Job ID: 2012-07-4491-ALTCOMM

has permission to Renovate the shell and egress update

Jeanie Bourke - Re: 561 Forest

I have completed the building code review and have the following comments:

1 Front Elevation  
 A2.1 SCALE: 1/4" = 1'-0"

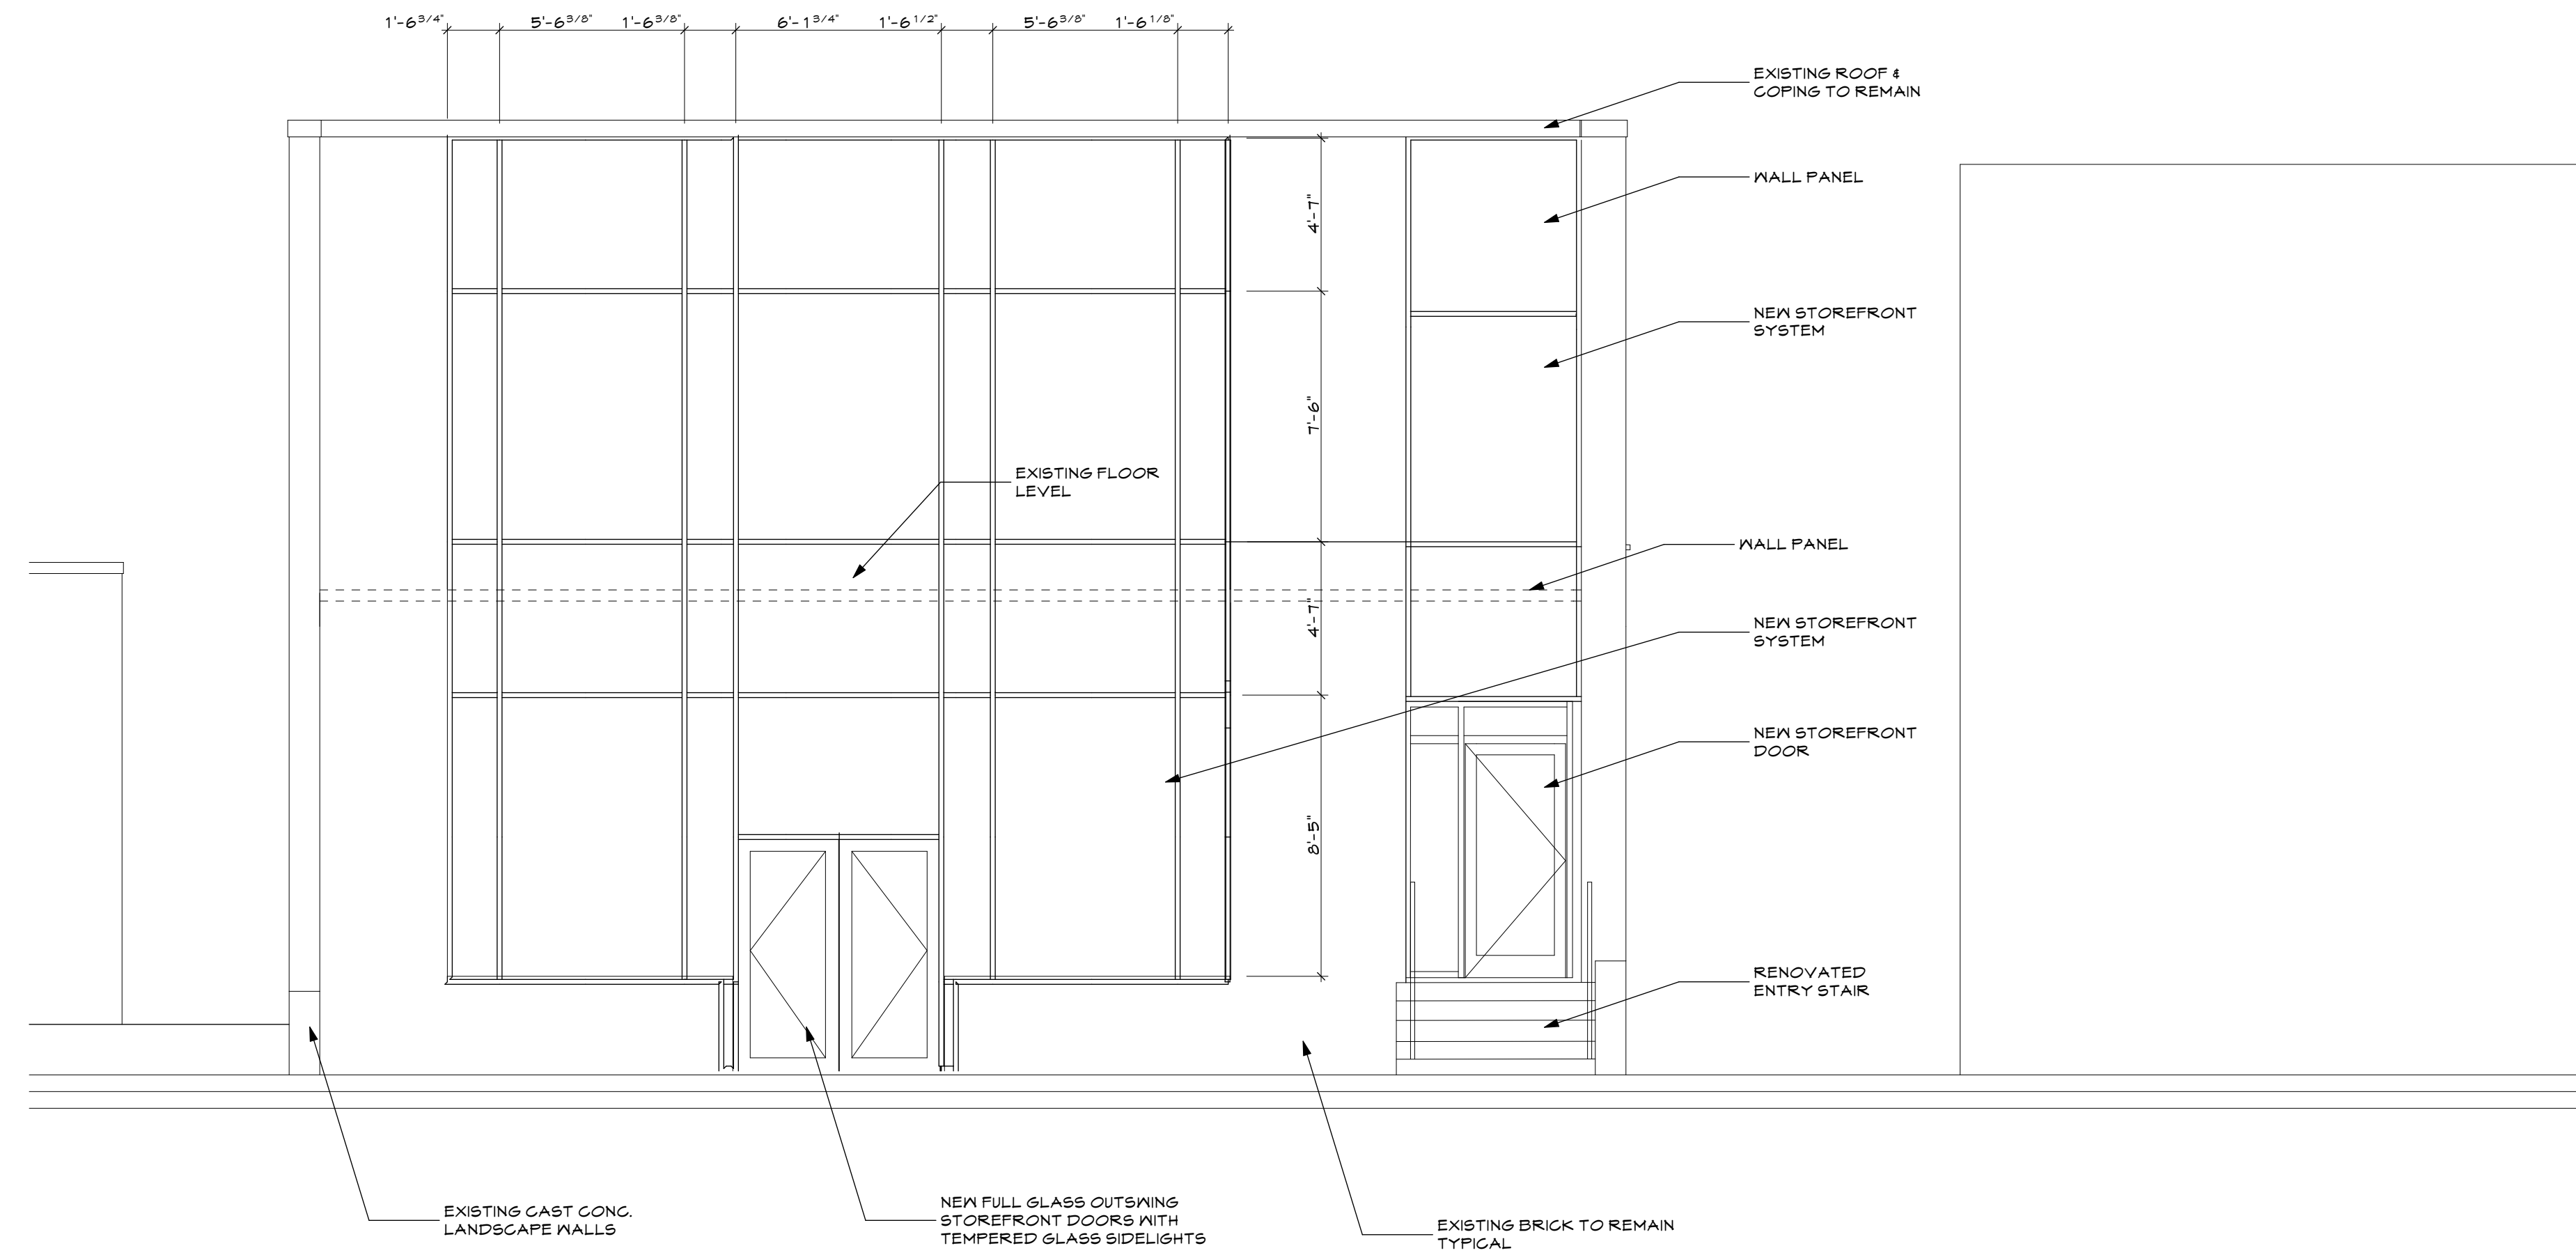
1. The plans are required by state statute to be stamped - DROP OFF A STAMPED SET OR REDO THE DISC OR BOTH ? MY BAD
2. Please confirm tempered glazing will be used in hazardous locations per Sec. 2406, specifically in stairwells. WILL DO Also, confirm compliance with the Energy Code for U-factor or SHGC, -I'LL GET THAT- and are there any new R.O. for windows, or are all of these in existing openings? IN EXISTING OPENINGS. I'VE RECEIVED THE SPECS FROM KAWNEER- ATTACHED HERE-

You can use the 1600 Wall curtain wall system in 4-3/4" depth. The sightline is 2-1/2" for an overall dimension of 2-1/3" x 4-3/4". The part number for the mullion is 807-343 (see attached PDF part #4) as you will see referenced below for steel requirements.

Intermediate: 807-343 Mullion (**typical captured vertical for 4 3/4" system**) with 120" of 1 1/2" x 1 3/4" Steel bar (oriented in the strong axis) – centered between the top intermediate anchor and the top of the member at the head

Jamb with 6'0" DLO: 807-343 Mullion with 120" of 1 ½" x 1 ¾" Steel bar (oriented in the strong axis) – centered between the top intermediate anchor and the top of the member at the head

Jamb with 1'6" DLO: 807-343 Mullion with no steel required
